PCD NO: PPR2350

3980 WALKER ROAD
 SITE PLAN DOCUMENTS
 EL PASO COUNTY, COLORADO

V3_Site Development Plan with Contours.pdf Markup Summary

REVISION DESCRIPTION (DESCRIPTION)	
REVISION DATE	
000000	
NORTH	
SCALE: 1" = 30'	
PROJECT #: 2310-0398	CHECKED BY: BML
DATE: 06/17/2024	DRAWN BY: EDM
SHEET #	2
TOTAL SHEETS	2

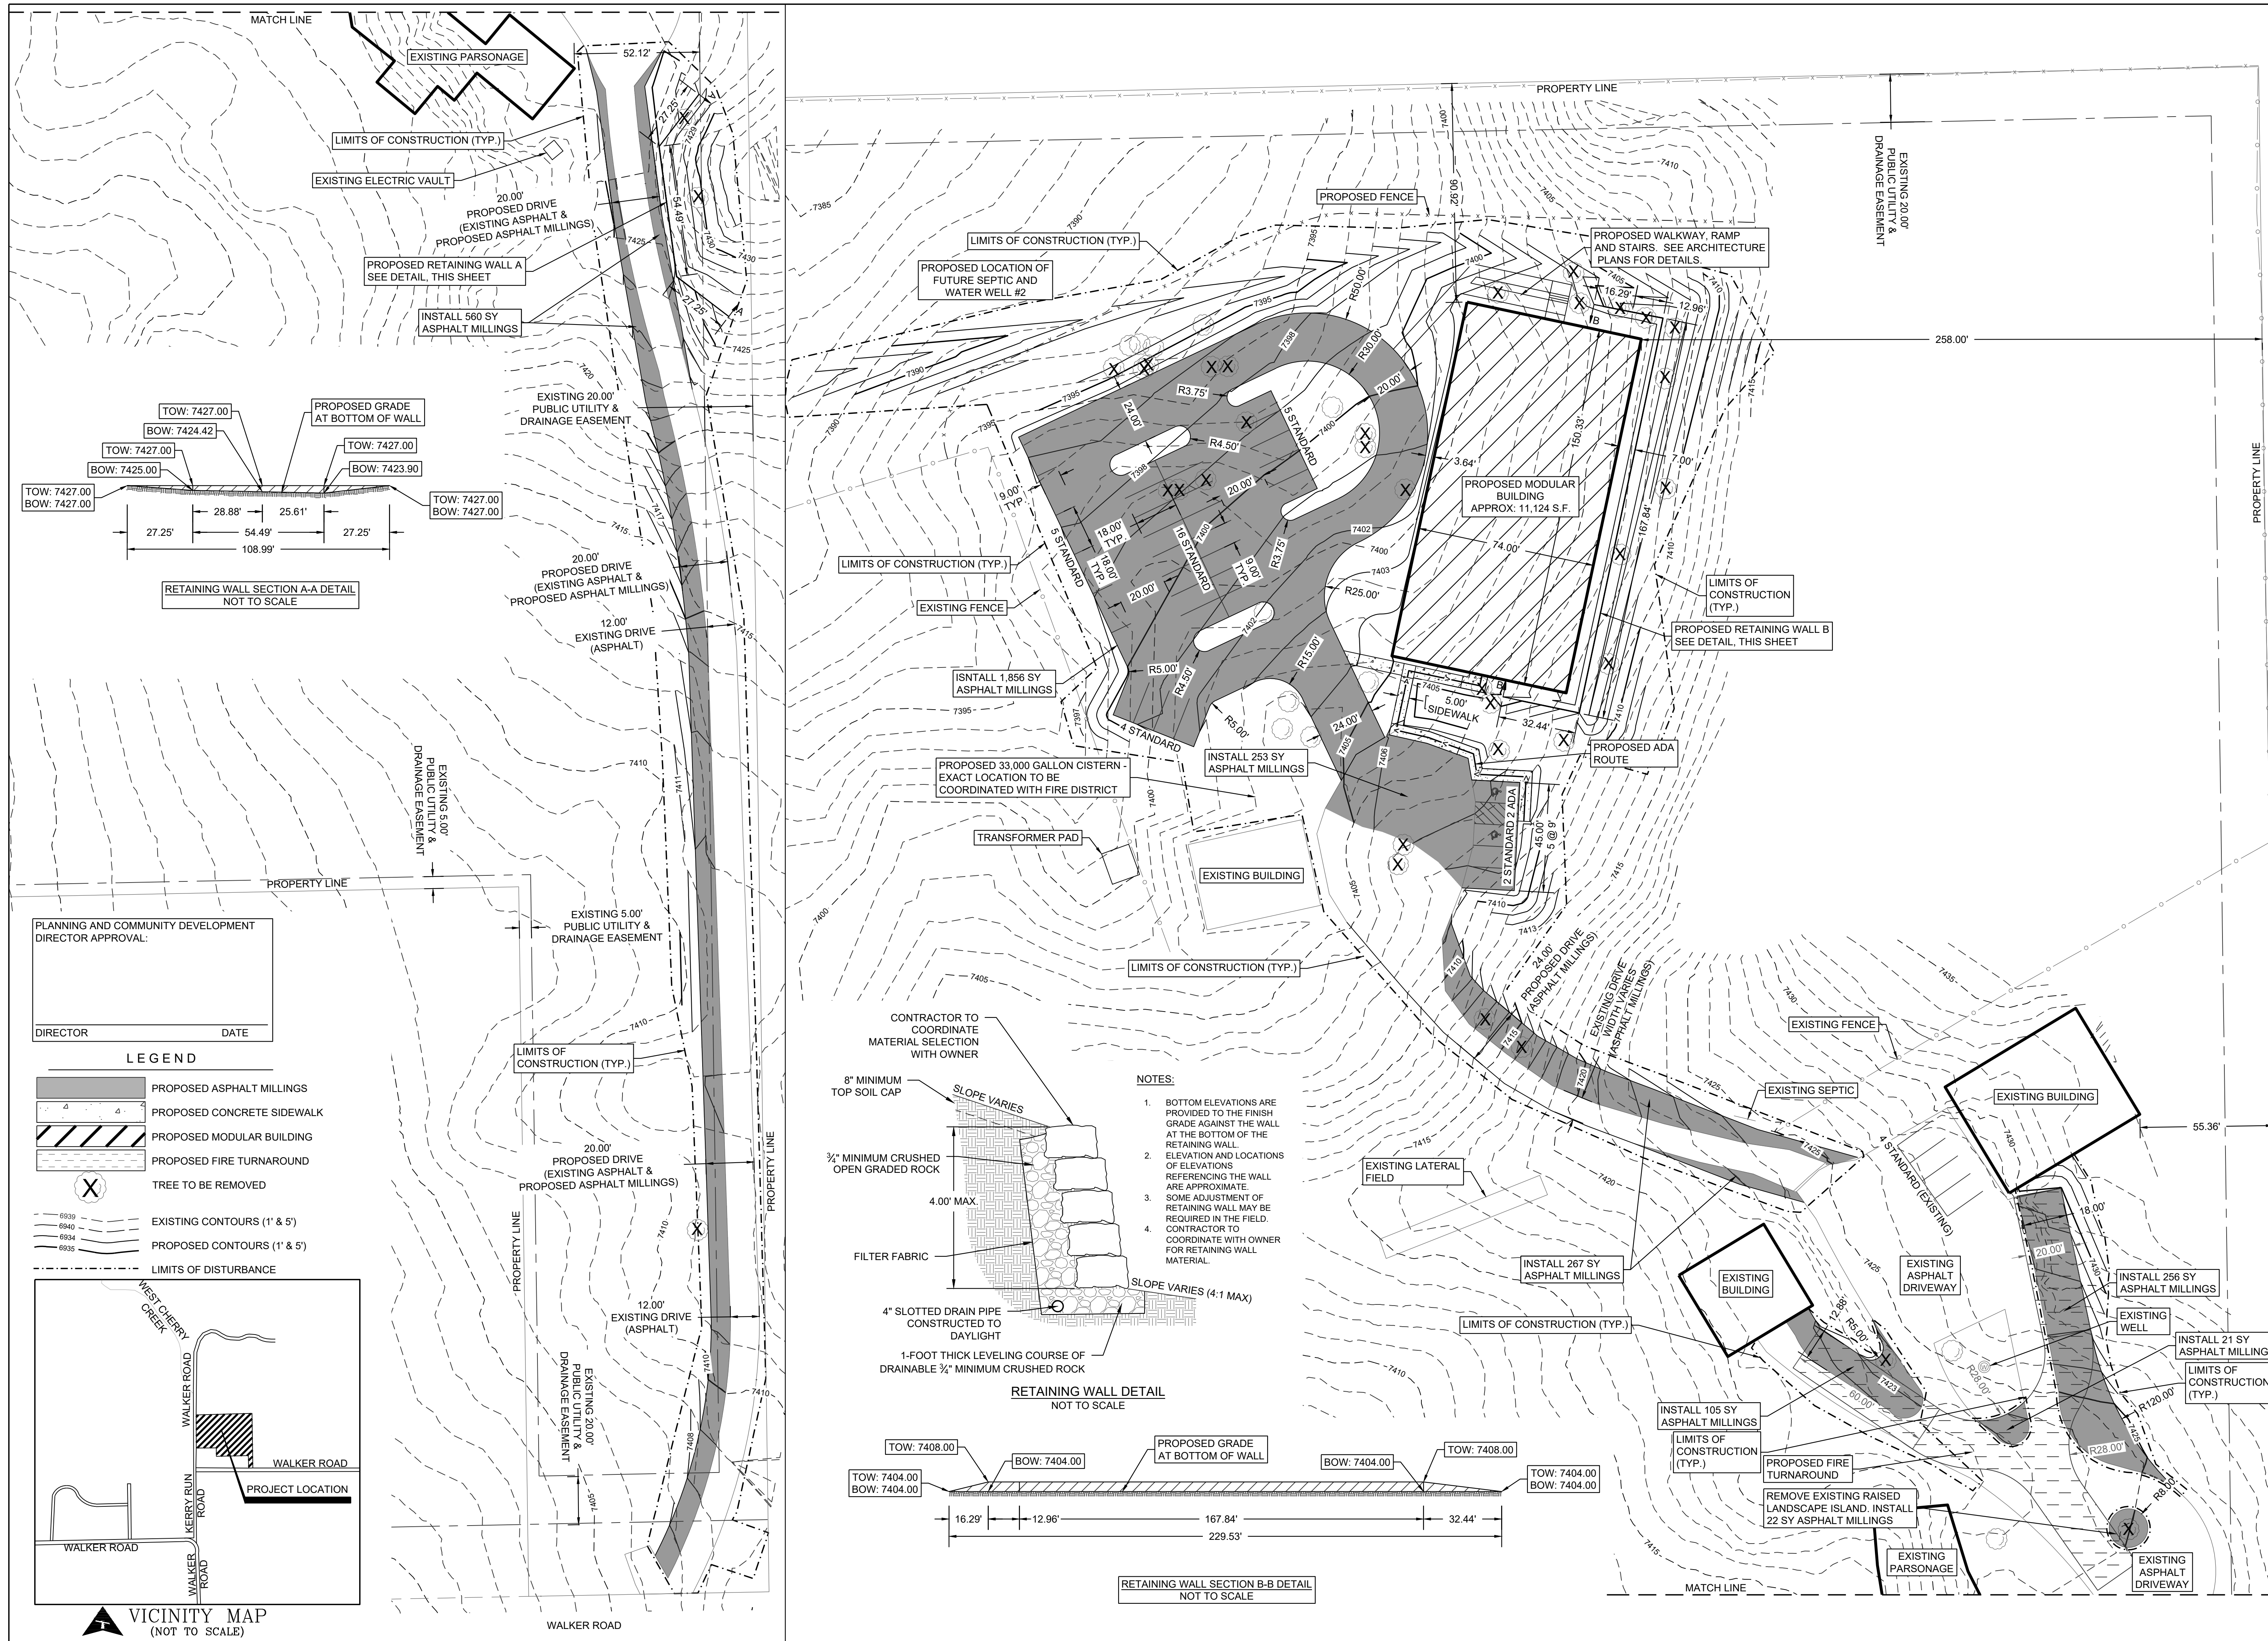
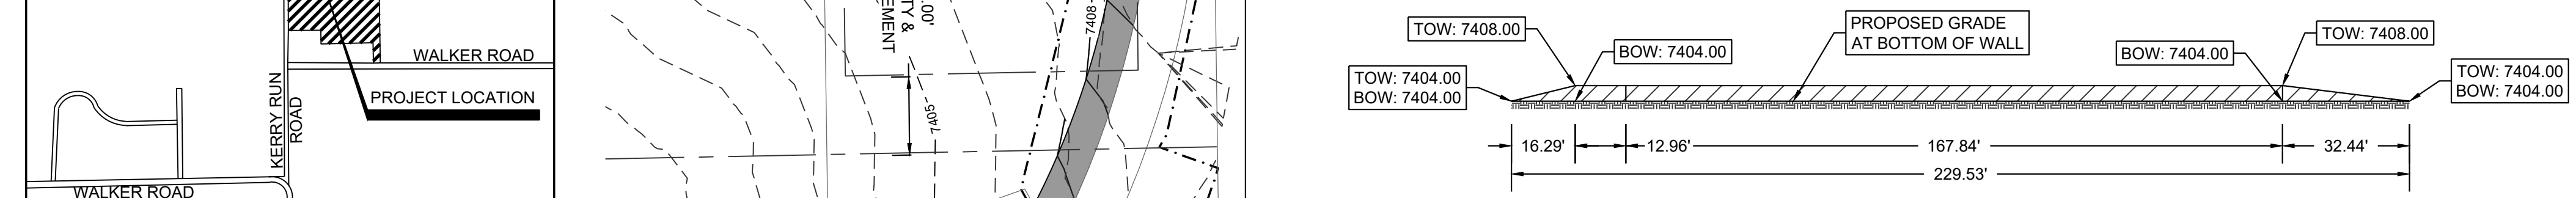
please show all proposed contours and grading that was recently done to the property. Please show the limits of disturbance
